Attention: Director Infrastructure Projects

My submission concerns the Woolgoolga to Ballina upgrade of the Pacific Highway, specifically the Broadwater National Park to Richmond River section (section 9).

The application number is SSI-4963.

Figure 13-24: Heritage item 26 Maloney property, Broadwater

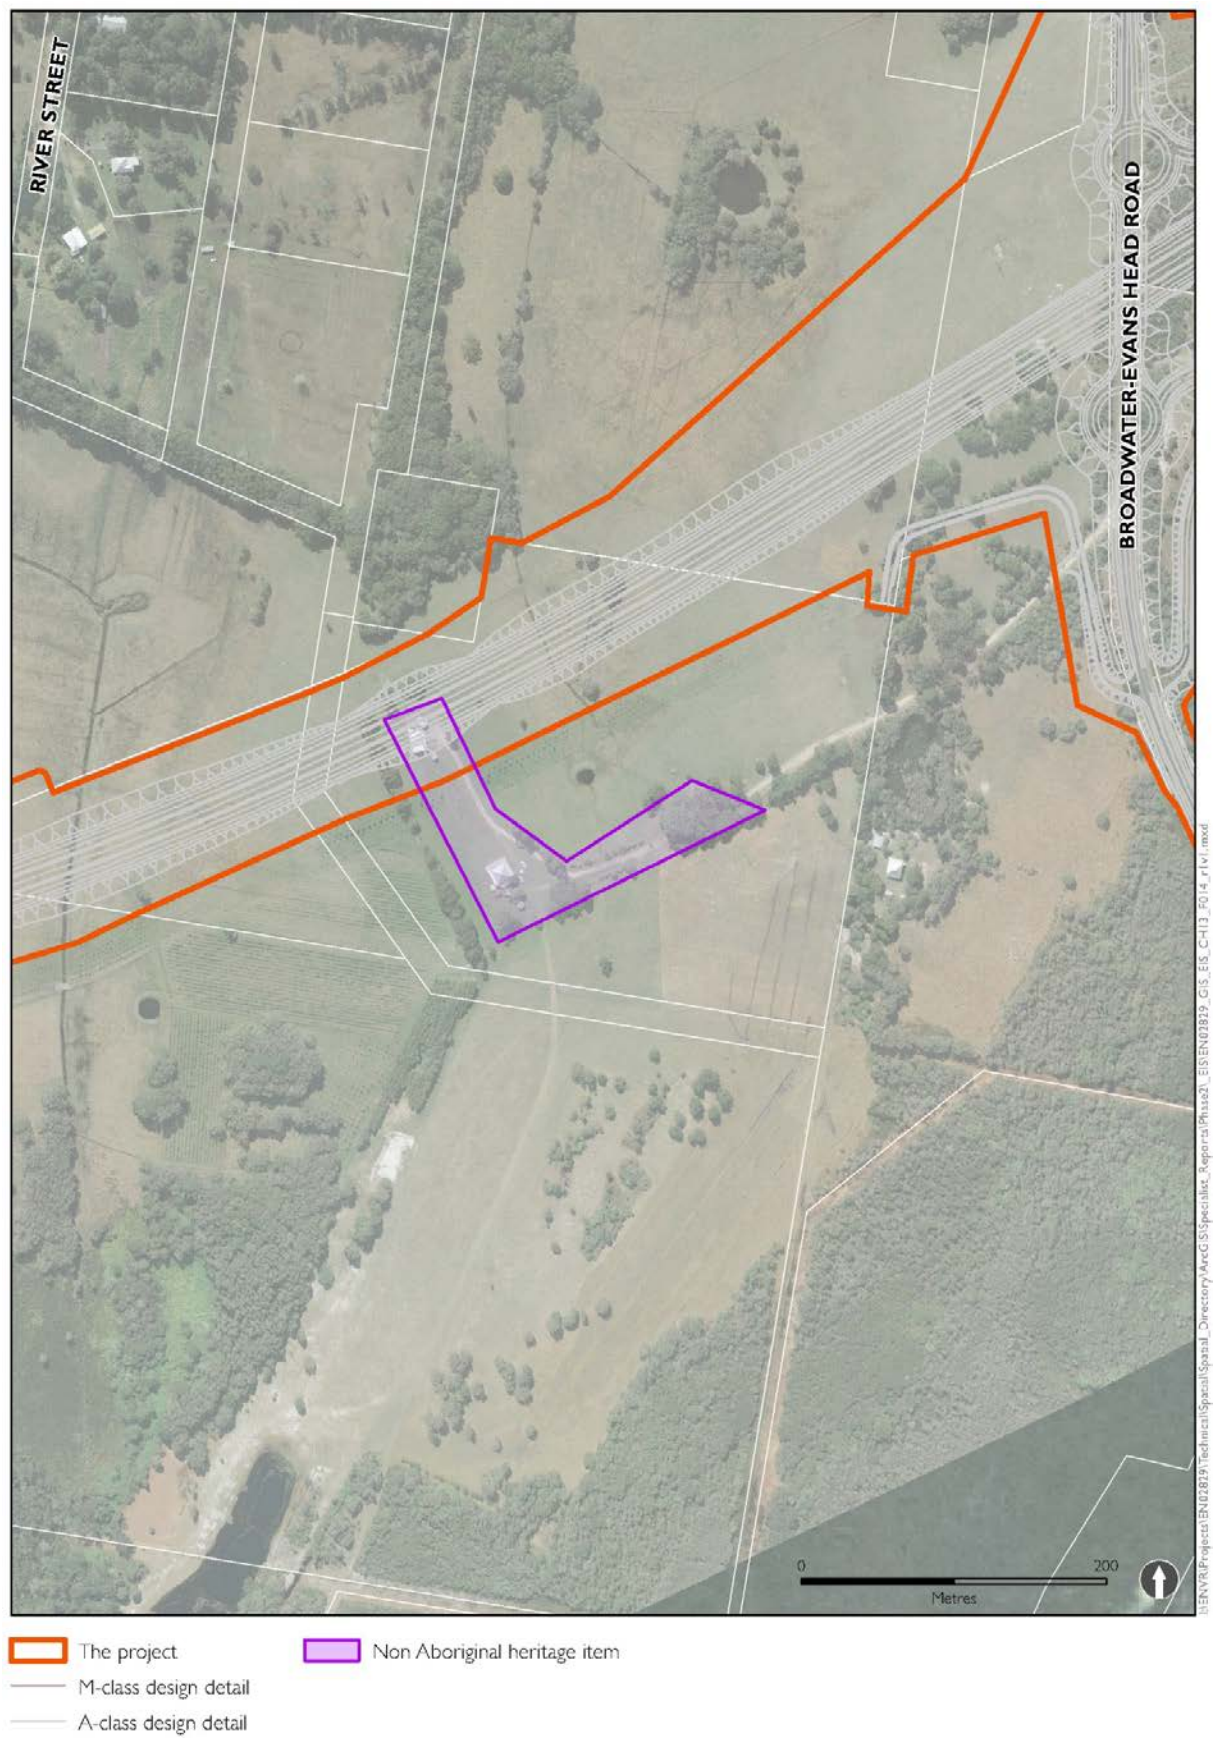
The house and property in which I live has been in the family for over 100 years (since it was first taken up from the government in the 1800's) and the house was built in 1901 (built by my great grandparents). It is a "queenslander" style, being of wood and corrugated iron construction with wide verandas built on three sides (all approximately facing towards the new freeway- with one veranda closed in).

I am concerned that the noise penetration and perception will be significant to this house with its wooden construction (noting that current outside levels are low).

Given all these factors I would ask that sizable measures be undertaken to mitigate the impacts of the upgraded highway during construction and under operational conditions. These measures should take into consideration the heritage value and construction of the house where appropriate.

I would ask that these measures include mitigating works to the highway form including low noise pavement and no "multiple noise bumps" on sides of the highway. Also noise barriers appropriate to the section of upgraded highway

adjacent to my house and any other appropriate measures.

It is also identified in the EIS 13.4 Management of impacts (item 26-HH41) that "The homestead has been identified for architectural noise treatment to control noise levels from the highway. The noise controls would be developed in consultation with a qualified heritage consultant to minimise impacts on the heritage significance of the item. A more detailed Statement of Heritage Impact (SOHI) would be prepared when the specific architectural noise treatments for the homestead are identified." It notes that this is to be carried out pre-construction.
